Development Facilitation Team (DFT) – Review Comments

DRB Project No: PR-2020-004432 Date: 04/12/2023 Agenda Item: #4 Zone Atlas Page: M-14

Location: [245 WOODWARD RD SE BETWEEN WILLIAM ST SE and SAN JOSE DRAIN]

Application For: SD-2023-00075-PRELIMINARY/FINAL PLAT (DHO)

Sketch Plat
for
Woodward Facility
Being Comprised of

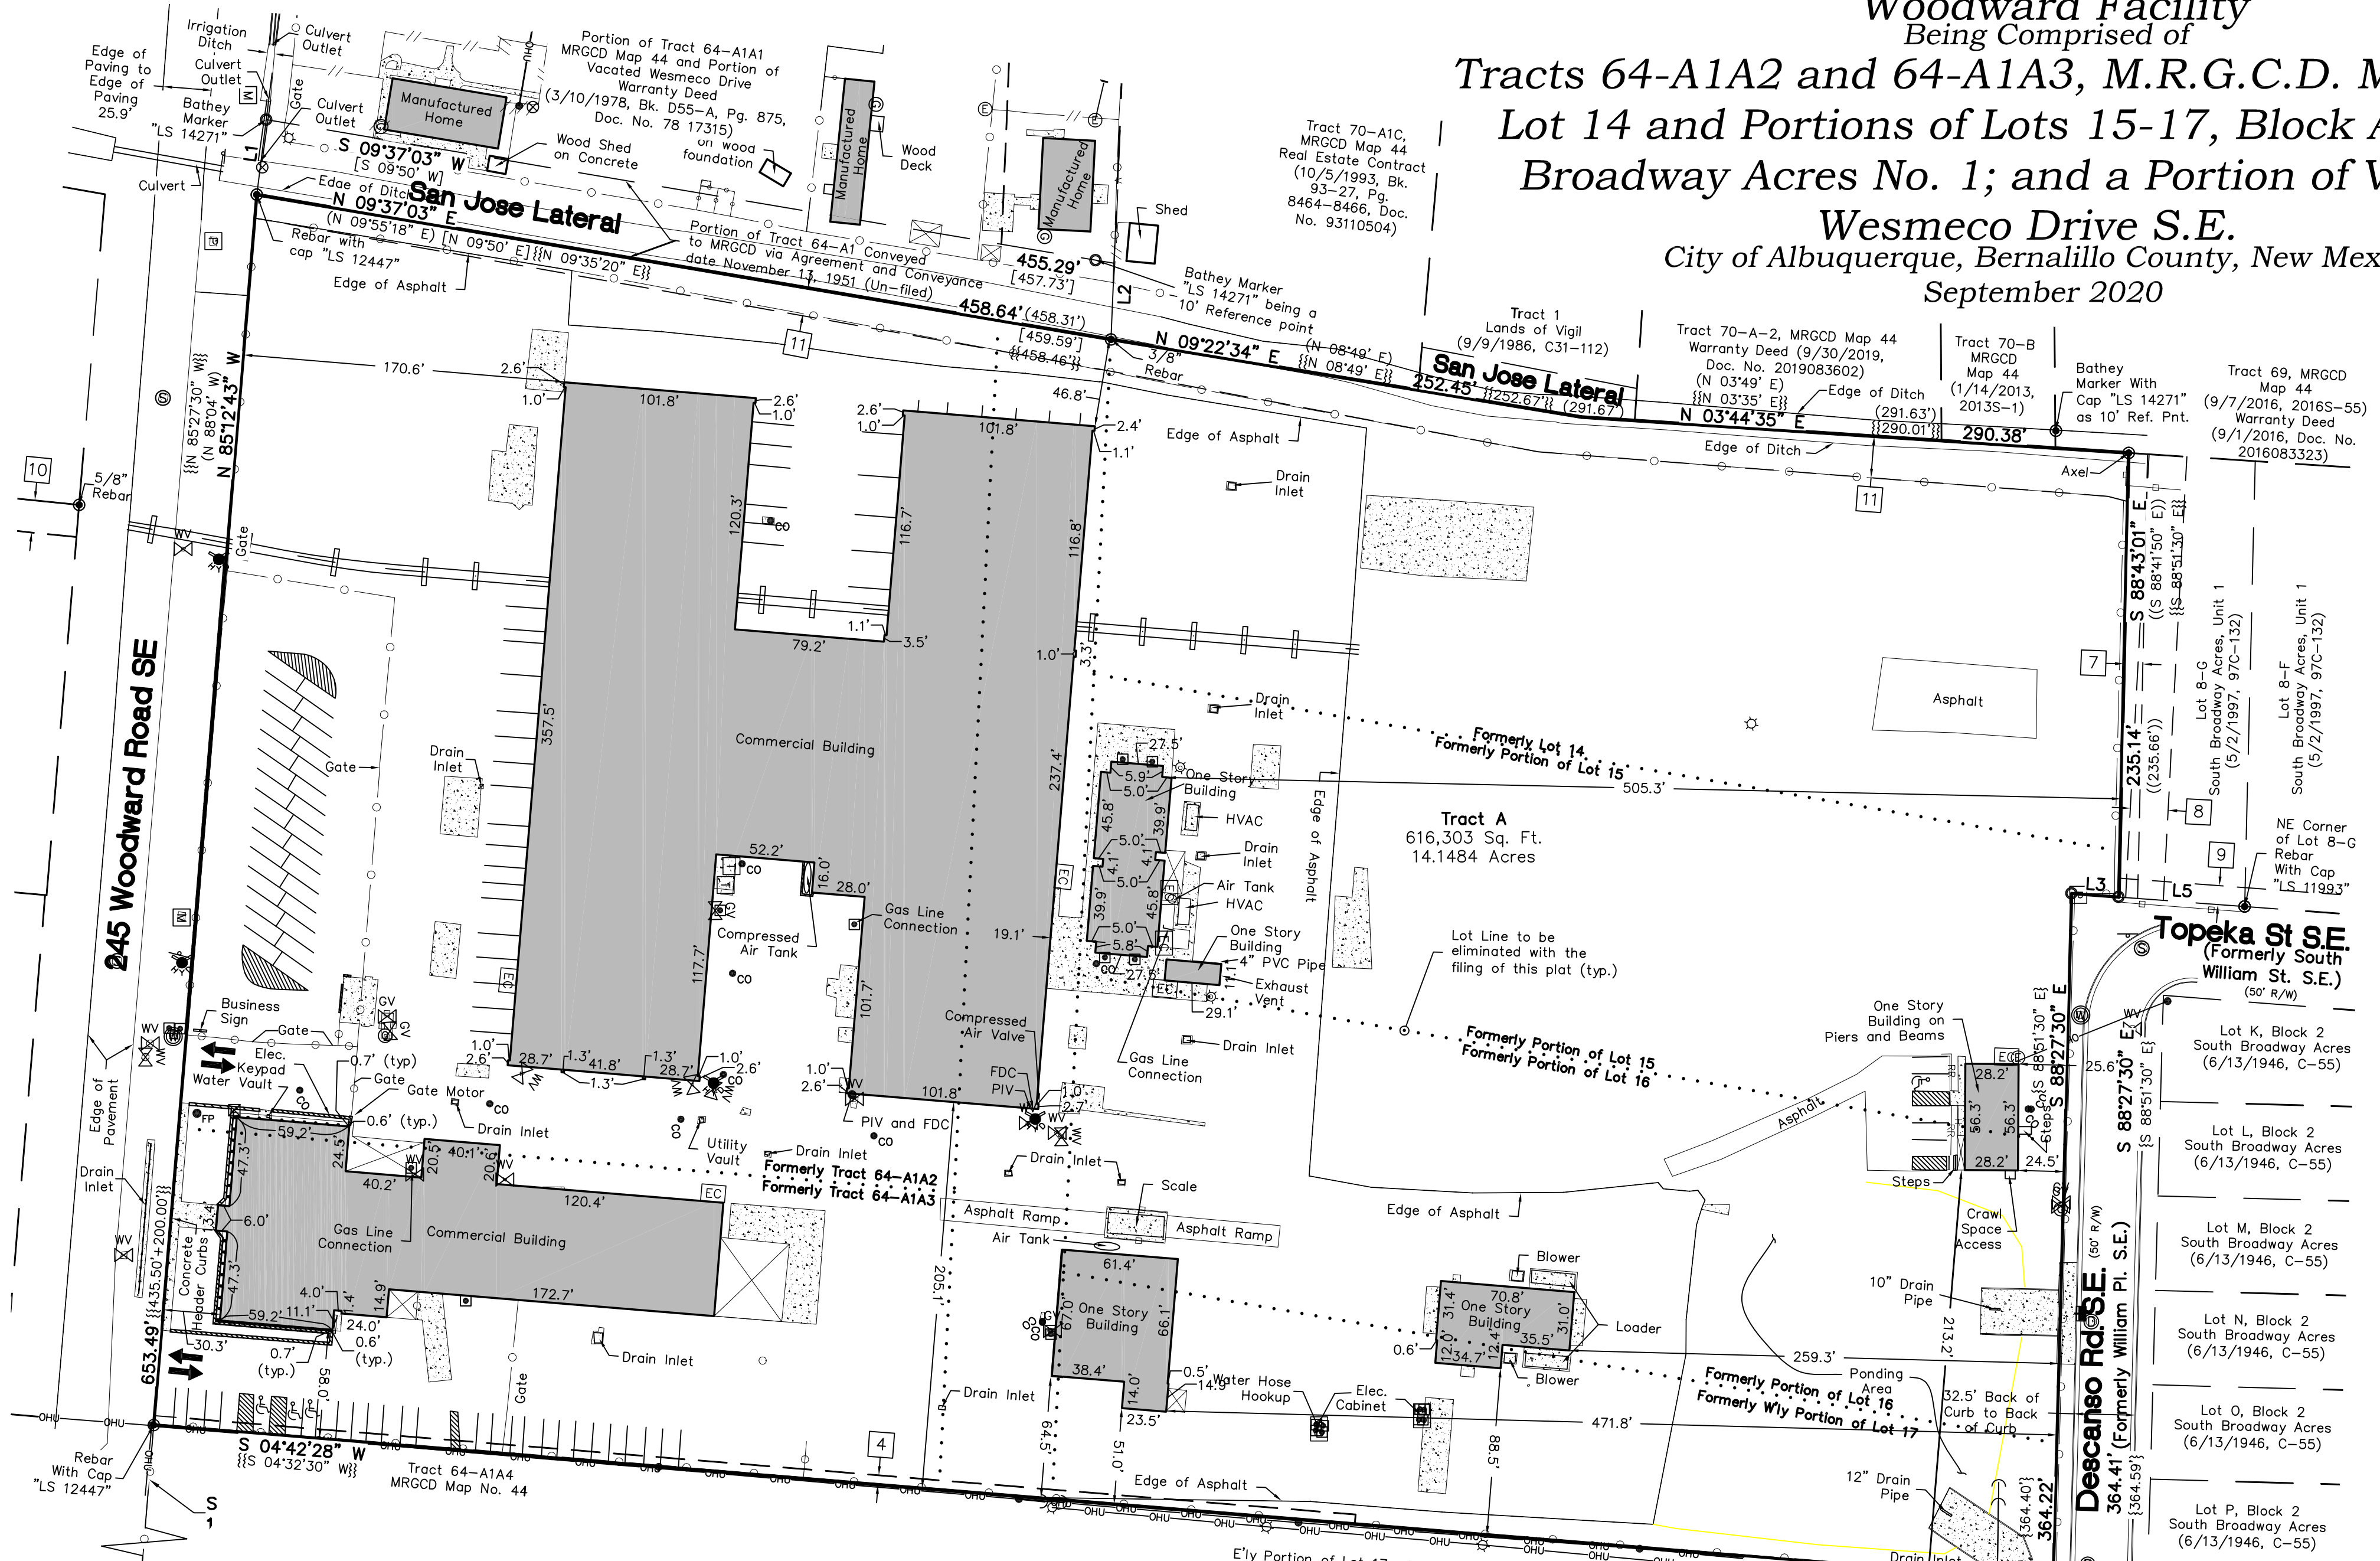
- The application number (SD-2023-00075) must be added to the Plat
- DXF approval from AGIS must be obtained.
- Descano is a local road and would require a 5 foot sidewalk and a 4 foot landscape buffer. Clarify with a sidewalk exhibit.

Confirm status of Descansos Rd. A landscape buffer may be required on all or a portion of this northern edge.

5-9 Neighborhood Edge indicates that any building must be no higher than 30 in the 100 feet adjacent to the R-1 zoned homes to the north of the subject site. See other requirements in that section related to parking and truck loading.

THIS SHEET SHOWS EASEMENTS BEING VACATED

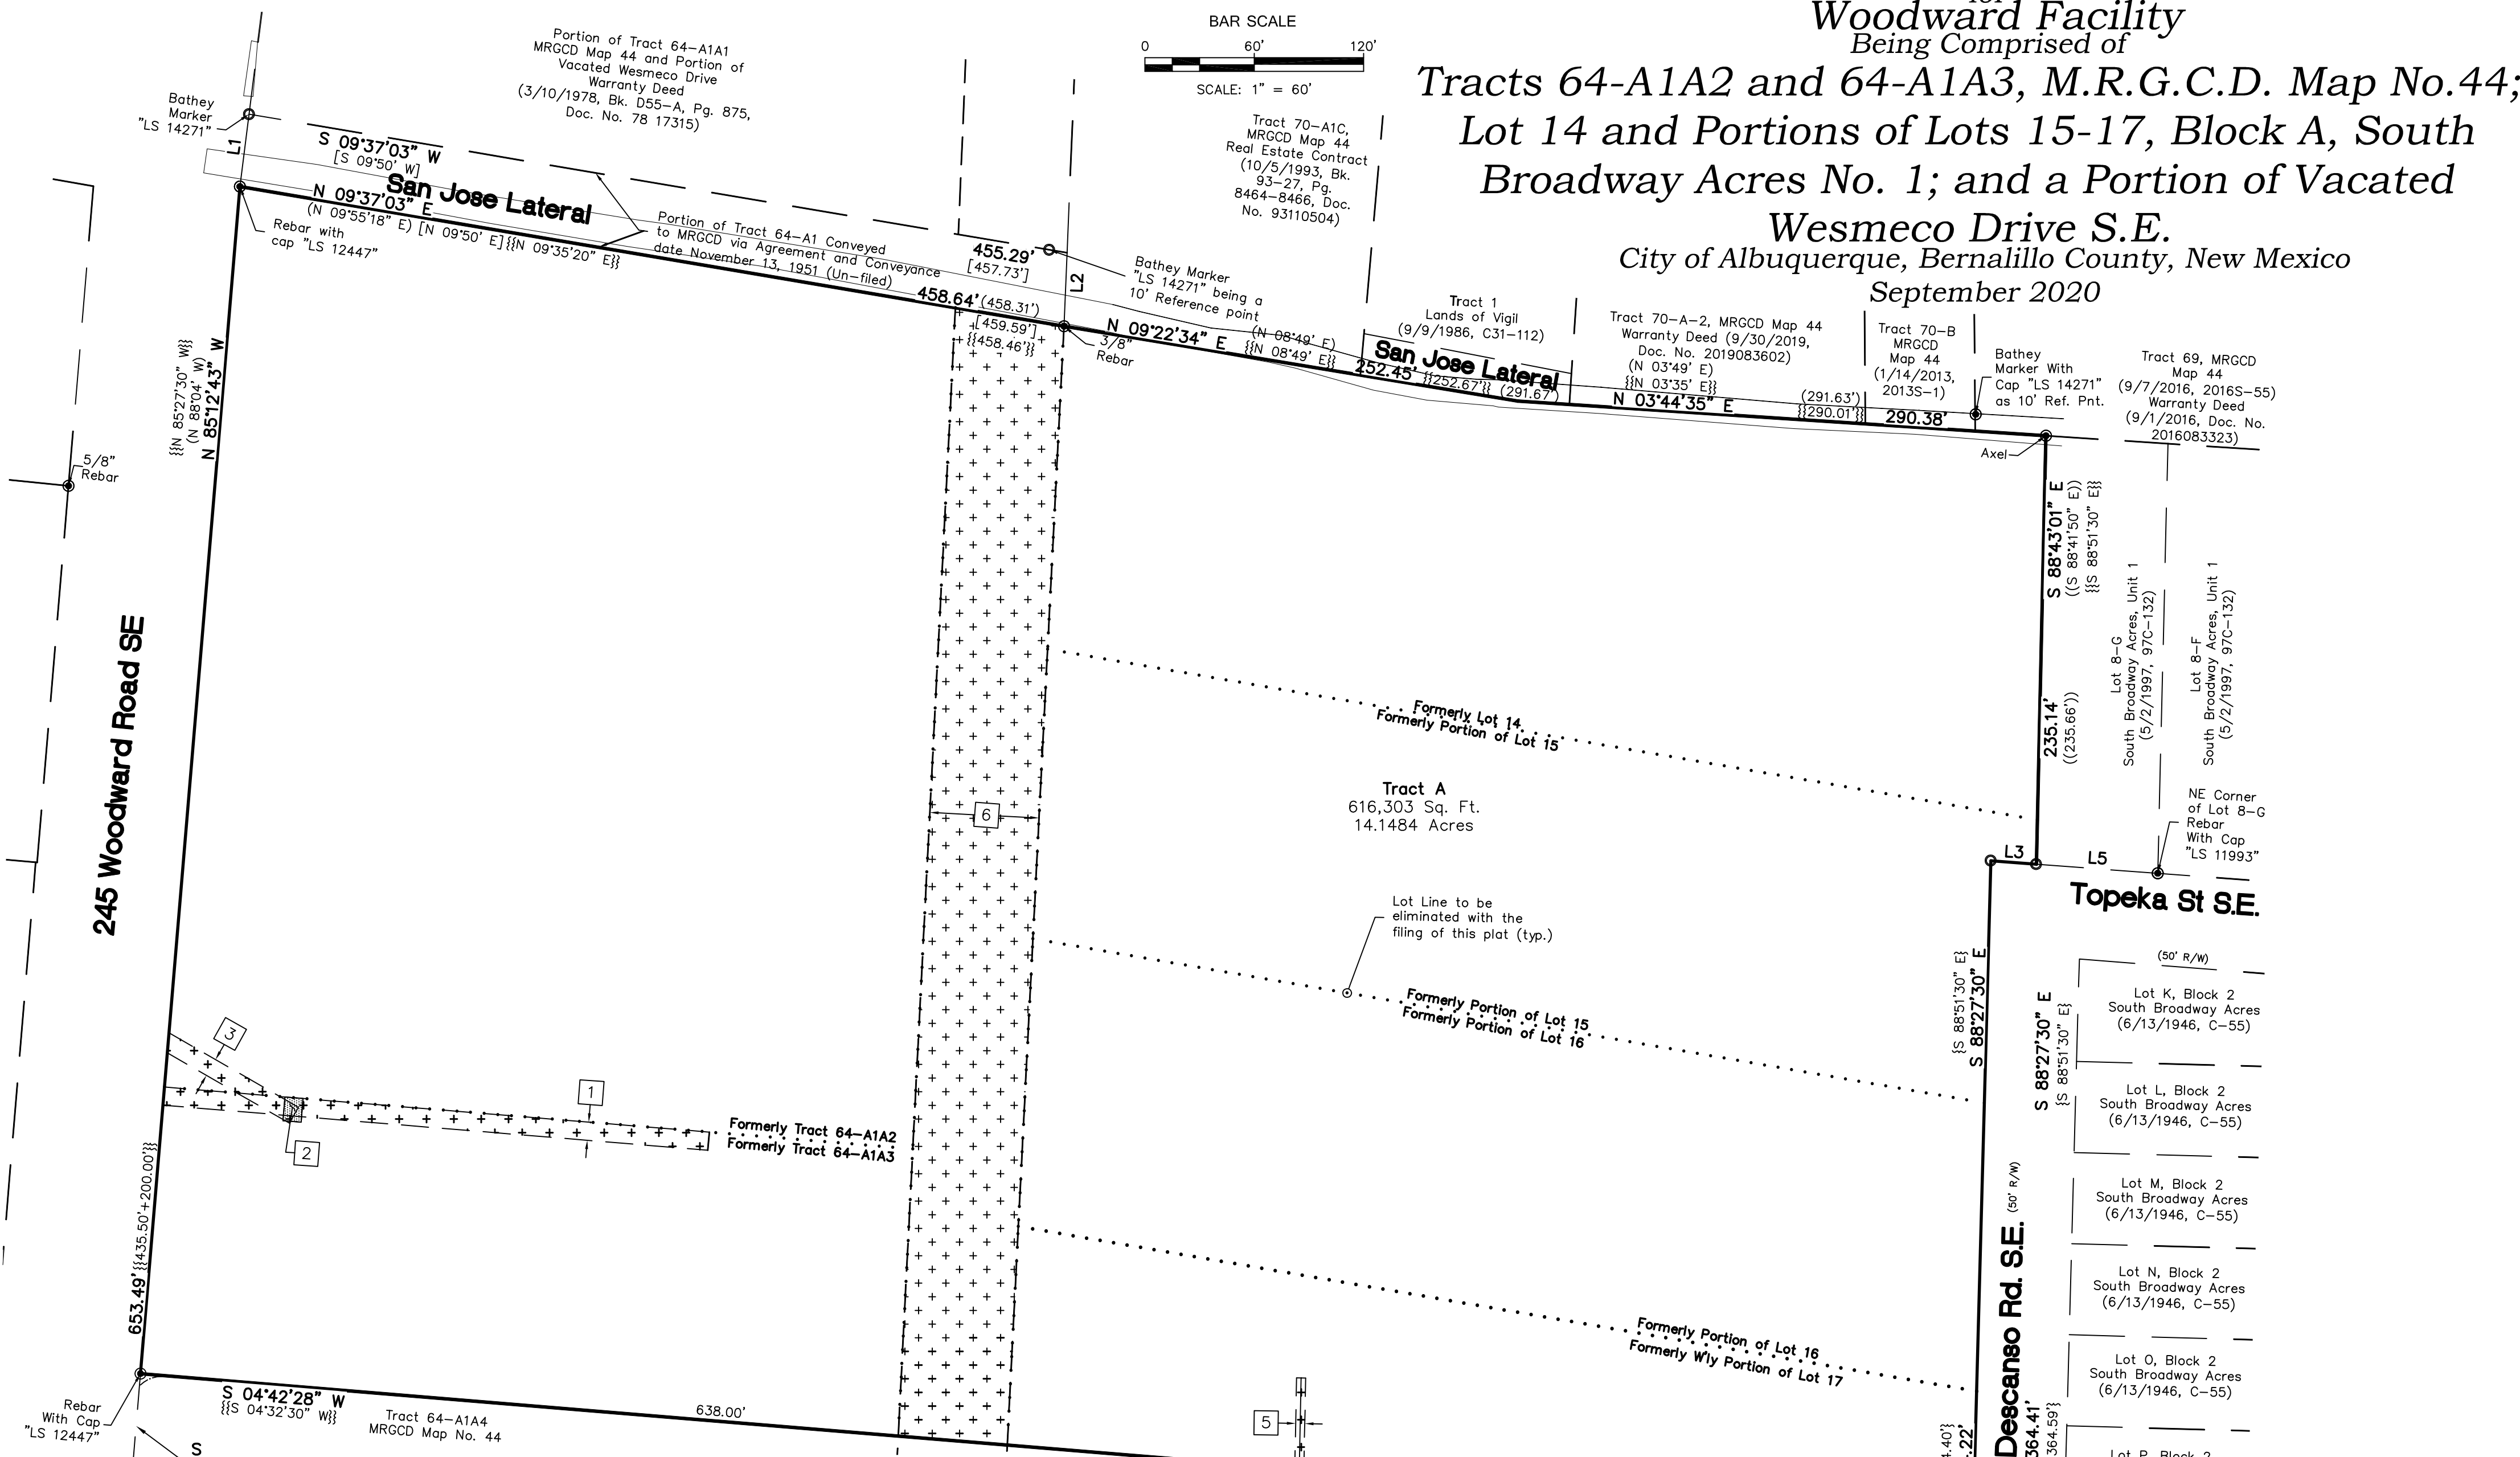
- The Applicant has justified the Vacations as follows:
 - Existing 10-foot PNM Easement – The easement was granted to provide space for an overhead utility line. The Applicant asserts that the public welfare does not require the easement be retained since there are no longer lines to protect in that space and PNM has signed off on the Plat.

- Existing 10-foot Anchor Easement for PNM and MST&T – The easement was granted to provide an anchor for the overhead utility line, which is no longer present. The Applicant asserts that the public welfare does not require the easement be retained since there is no anchor to secure or protect the removed overhead lines for the area, and PNM has signed off on the Plat.

- Existing 10-foot PNM and MST&T Easement – The easement was granted to provide space for overhead utility lines, which are no longer present. The Applicant asserts the public welfare does not require the easement to be retained since there are no longer lines to protect in that space and PNM has signed off on the Plat.

- Existing 5-foot down Guy and Anchor Easement for PNM and MST&T – The easement was granted to provide an anchor for the overhead utility line. The Applicant asserts that the public welfare does not require the easement to be retained since there is no anchor to secure or protect the overhead lines for the area to the east of the subject property, and PNM has signed off on the Plat.

- Portions of Existing Public Utility Easement – This public utility easement was retained with the Vacation of ROW from Wesmeco Drive. The Applicant asserts the public welfare does not require the easement to be retained, , as there are only private utility services and objects in the area, and the large commercial building on the lot considerably encroaches into the easement. Furthermore, the utility companies have all signed the Plat depicting this Vacation.
-
